ADC PARKS & GREENSPACE ARBORICULTURE

PLANNING APPLICATION: WA/37/14/TC

ADDRESS: Lodge Cottage The Street Walberton BN18 0PJ

BRIEF DESCRIPTION: Prune back easterly lateral growth by 1.5 metres to 1 No Magnolia Grandiflora and 1 No Fig tree, fell and grub out dead and dying Leylandii and remove 1 No Purple Malus within the Walberton Village Conservation Area.

LODGE COTTAGE, THE STREET, WALBERTON, BN18 0PT

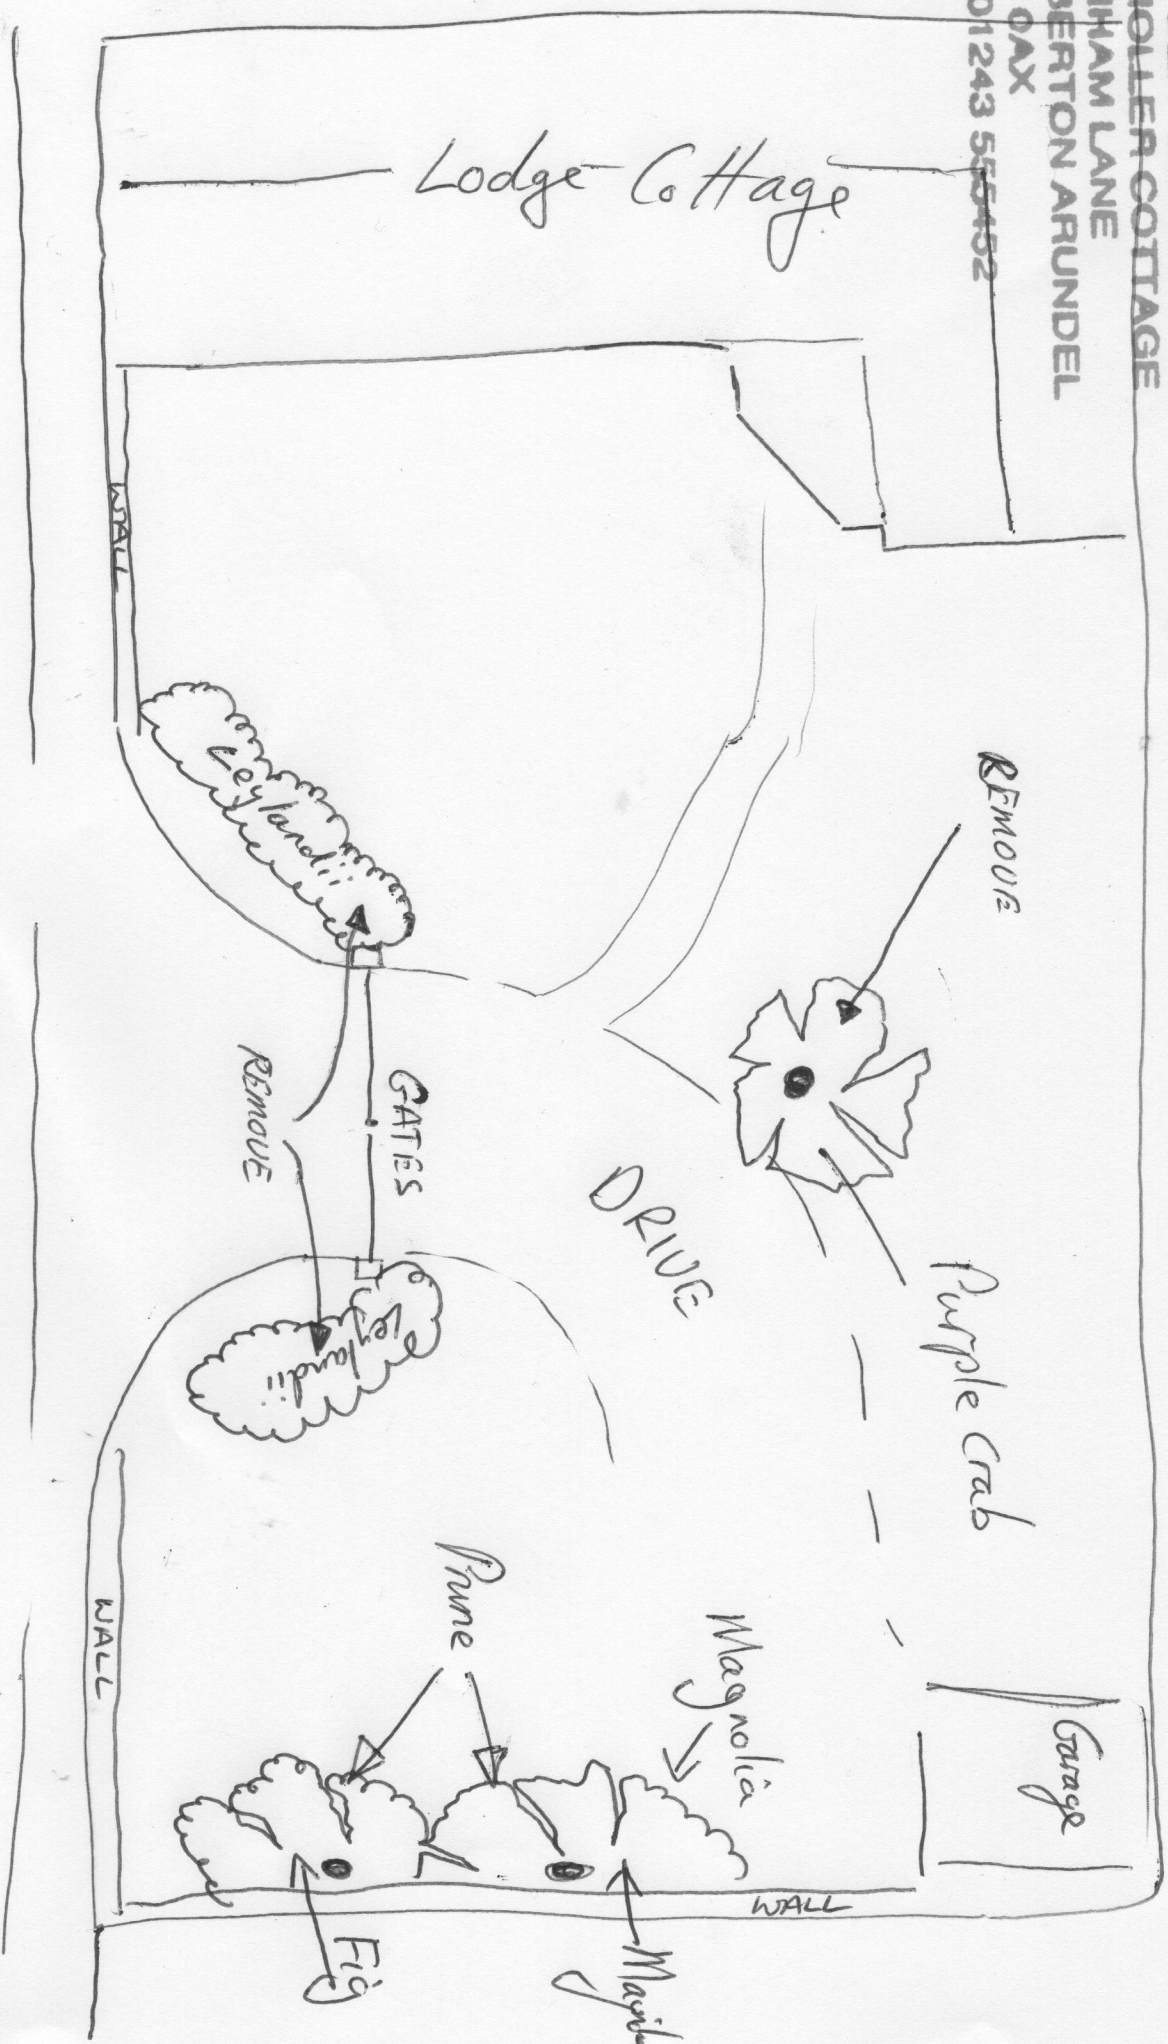
- Outlined trees are located in the high amenity area of Walberton village.
- All trees can be seen from the main road, due to their size however they have a limited impact on the landscape.
- **T-1** has leaned over significantly to the east, and would benefit from a reduction to allow apical growth to prevail.
- **T-2** has also got a lean to the east, should be rebalanced with an easterly reduction.

- **T-3** is in fair to poor condition. It has been pruned regularly, however foliage has started to die off in areas. It is also over a meter wide, and is encroaching into the garden area.
- **T-4** is in a poor condition, with less than 50% of the crown density you would expect from a healthy specimen of this species.
- Also the planting of a beech hedge along the boundary line would be in keeping with the landscape of the village, and arboriculturally speaking is sound practise.

- It would therefore be my recommendation that this proposed application of works **should be allowed with the below conditions.**

The Crown Reduction should not exceed the removal of single branch lengths which are greater than **1m** from the periphery of the original crown diameter. The branch removals should leave healthy substantial leaf bearing side branches. All side branches to be retained should be at least **1/3rd** in diameter of the removed branch. Pruning cuts must be flat and smooth, kept as small as possible by cutting at an optimum angle and should not exceed **100mm** in diameter.

Where whole branches are to be removed final cuts close to the trunk or branch union are to be made as shown in Figure 2 of BS3998:2010 and all shortened branches are to be cut at the correct angle (see also BS3998:2010) and adjacent to a live bud or lateral.
